**Sydney Fish Market  
Concept and Stage 1 (SSD-8924) and Stage 2 (SSD-8925)**

## Attachment 1 – Key Issues

DA QUERY RESPONSE - FOOTPRINT OF BUILDING STRUCTURES OVER THE WATER (m²)

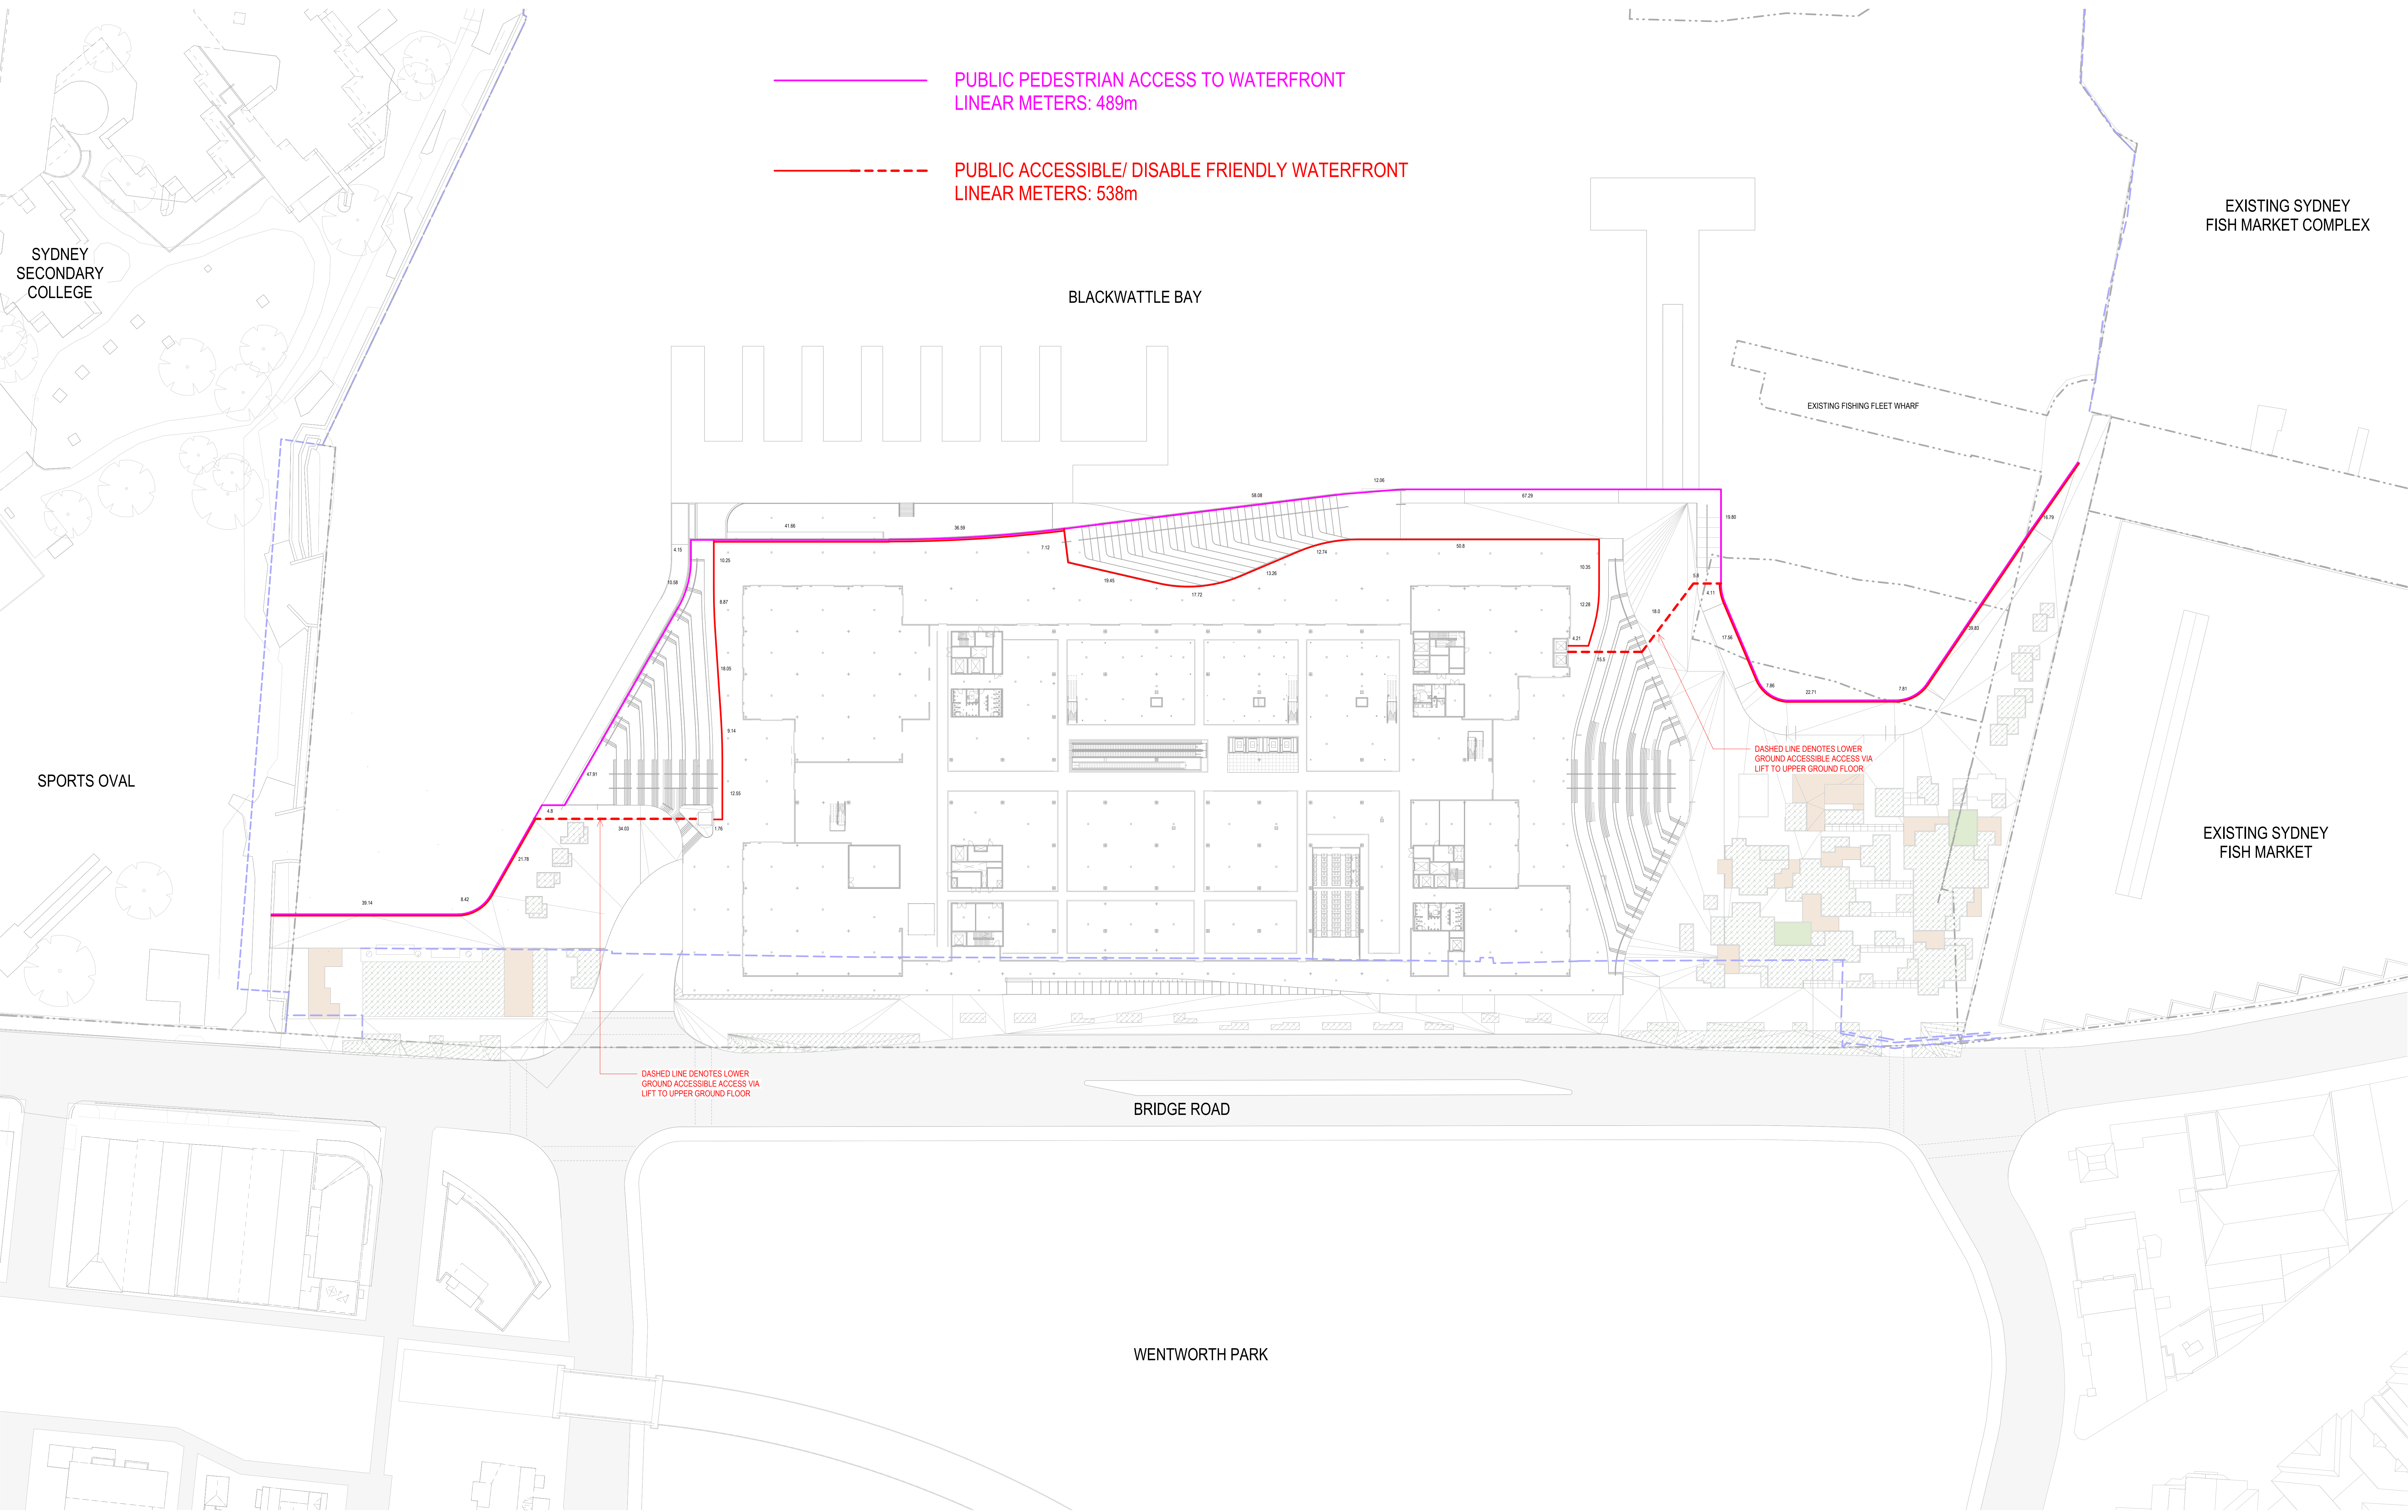
Please provide a comparison of the existing and proposed public domain/accessible areas, including before and after statistics on:

- footprint of building structures over the water (m<sup>2</sup>)
- linear metres of pedestrian access along the waterfront
- the footprint of wharves/navigation structures (m<sup>2</sup> and linear metres), by type of vessel serviced: publicly accessible to all; publicly accessible (e.g. cruises); fish market use only; and private use only

DA QUERY RESPONSE - PROVIDE PLANS ILLUSTRATING THE EXISTING AND PROPOSED PUBLIC DOMAIN/ ACCESSIBLE AREAS.

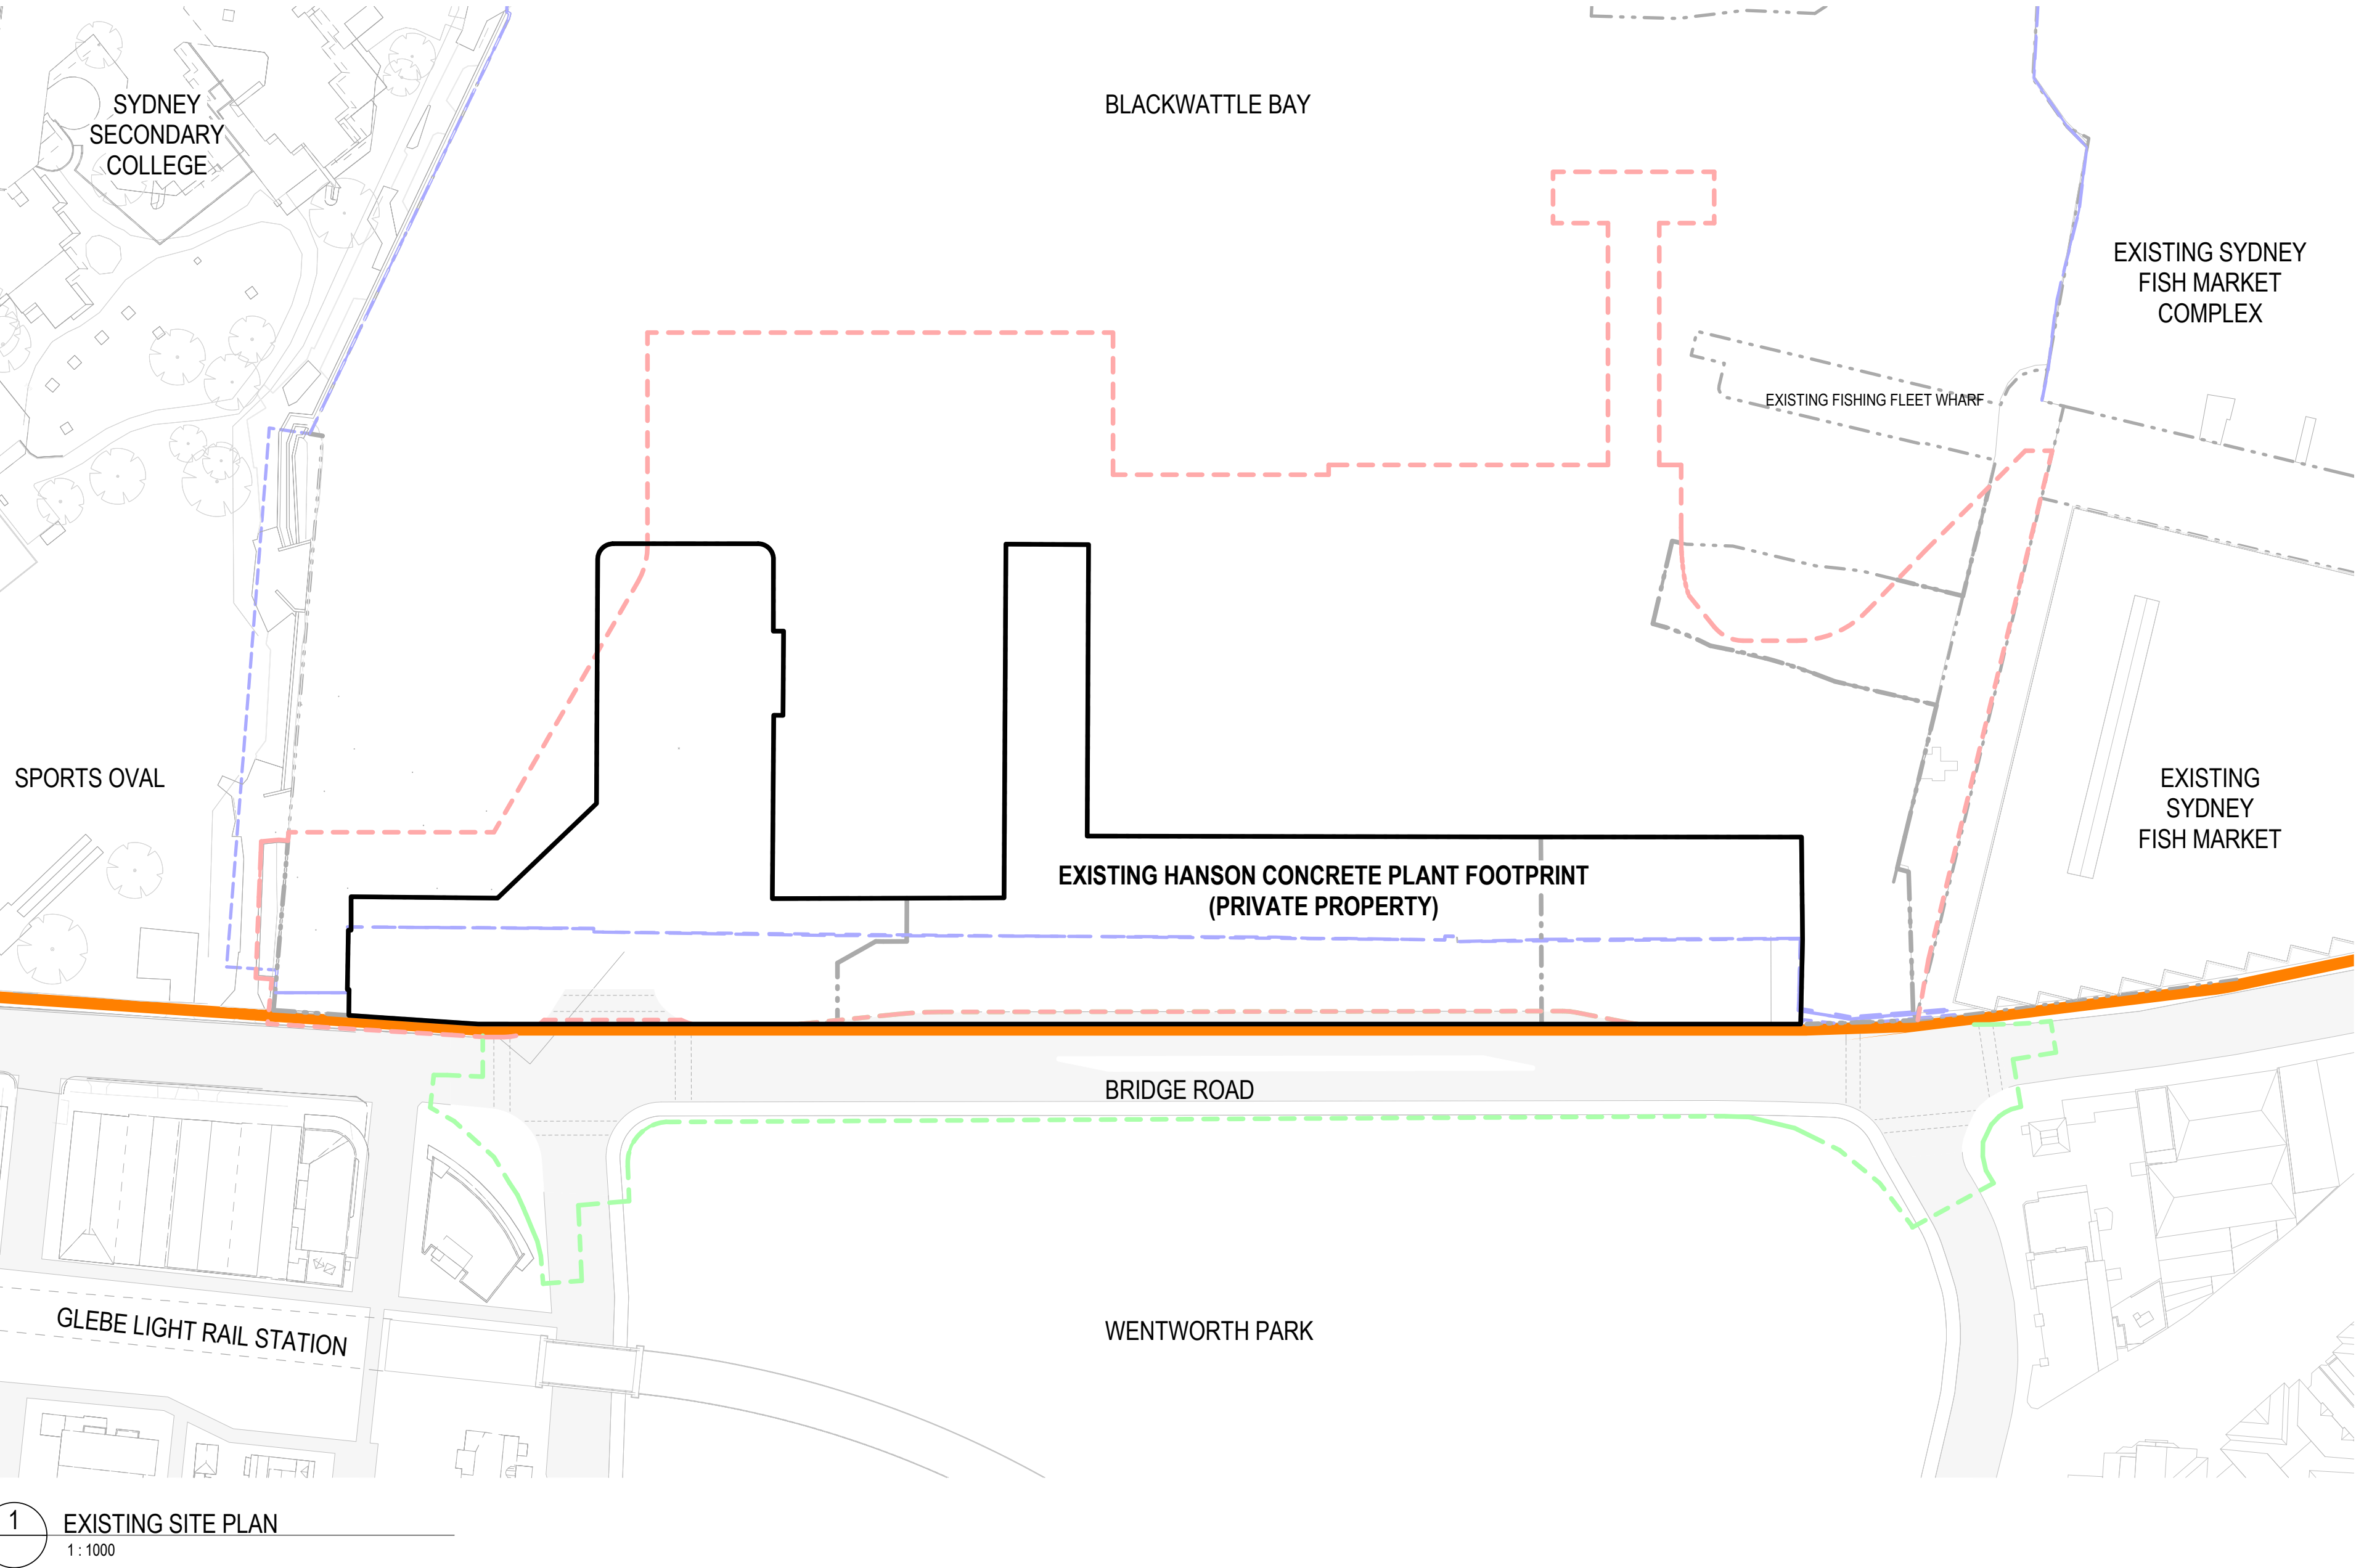
In addition, please provide plans clearly illustrating the existing and proposed public domain/accessible areas.

South Elevation
Scale 1:100

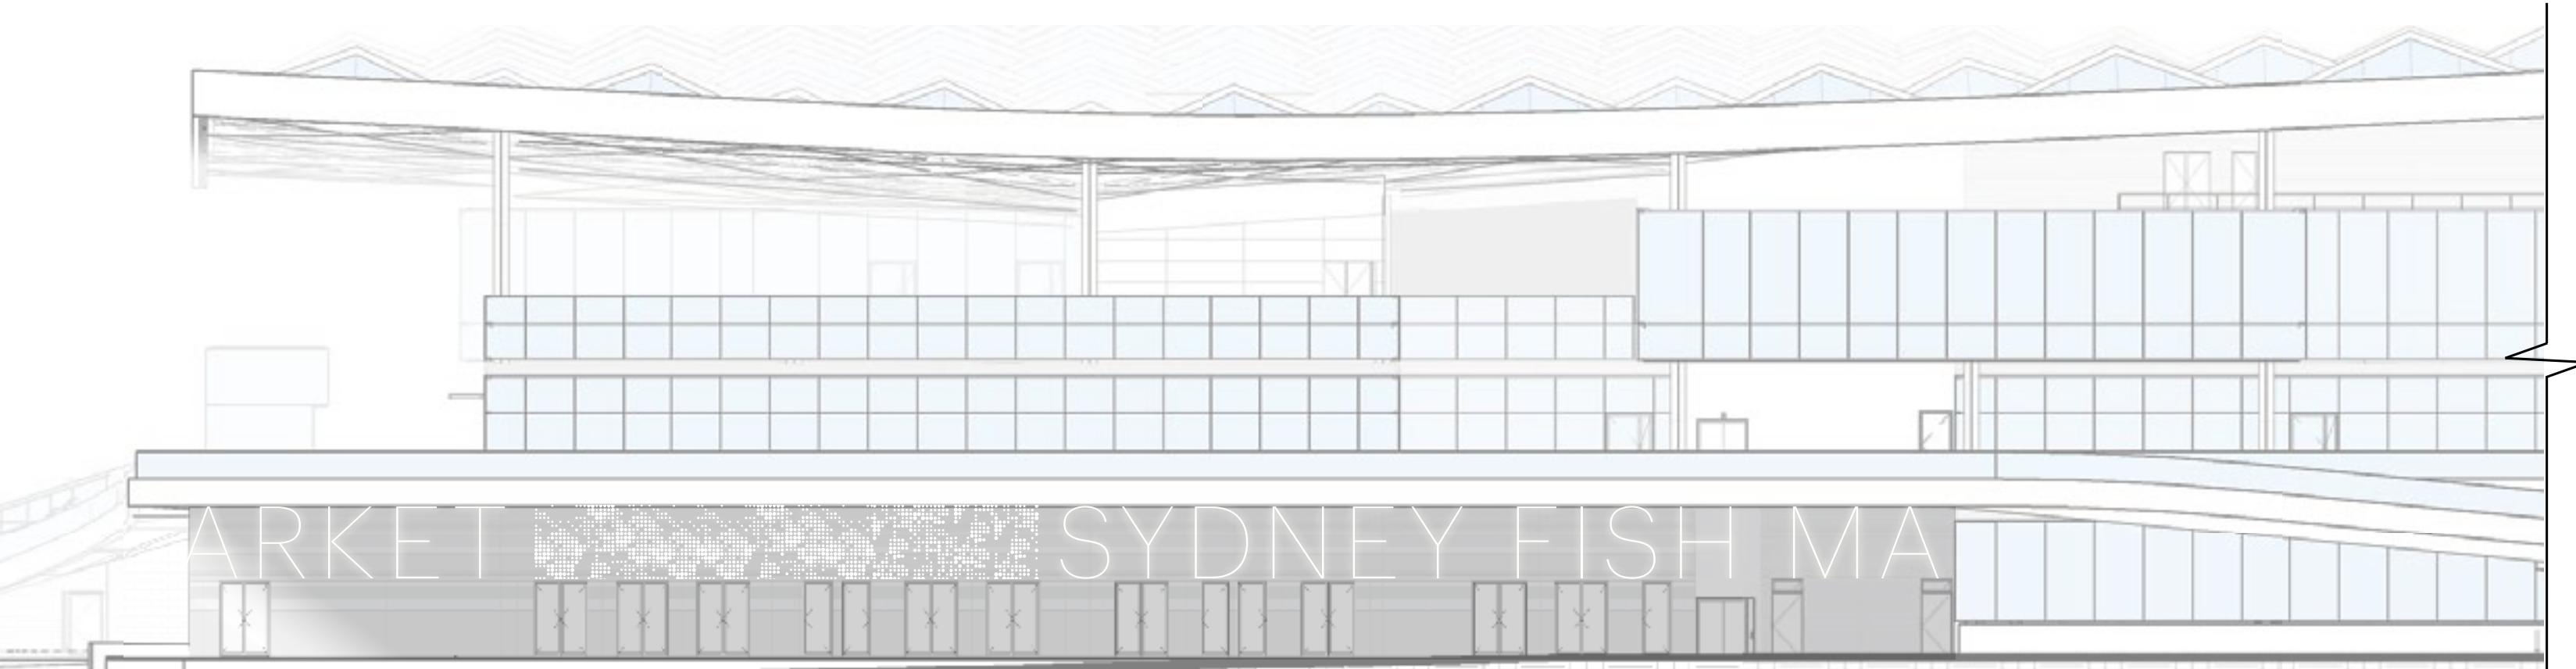
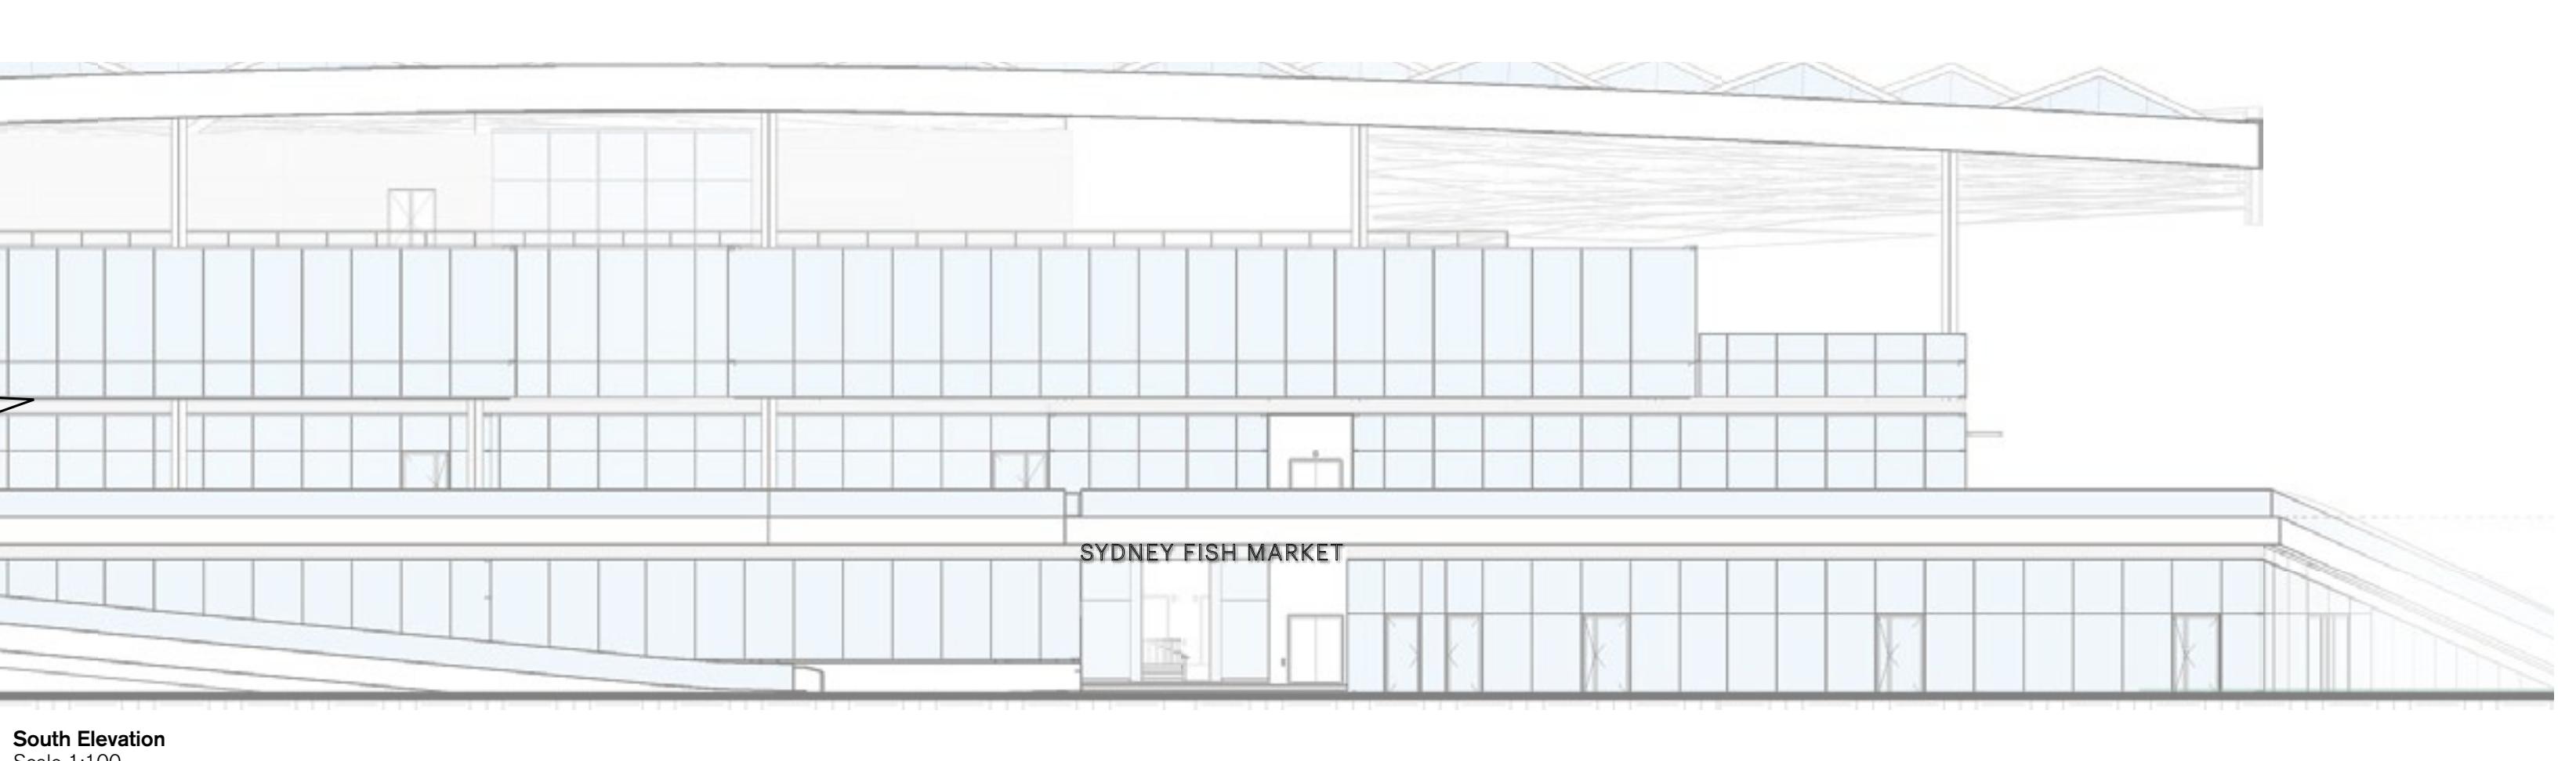
Provide a signage strategy for the proposal, with guidance from the architect(s), to ensure future signage is integrated into the building design (noting details and tenancy signage may follow in

subsequent DAs). Principles and zones for external signage should also be outlined as appropriate.
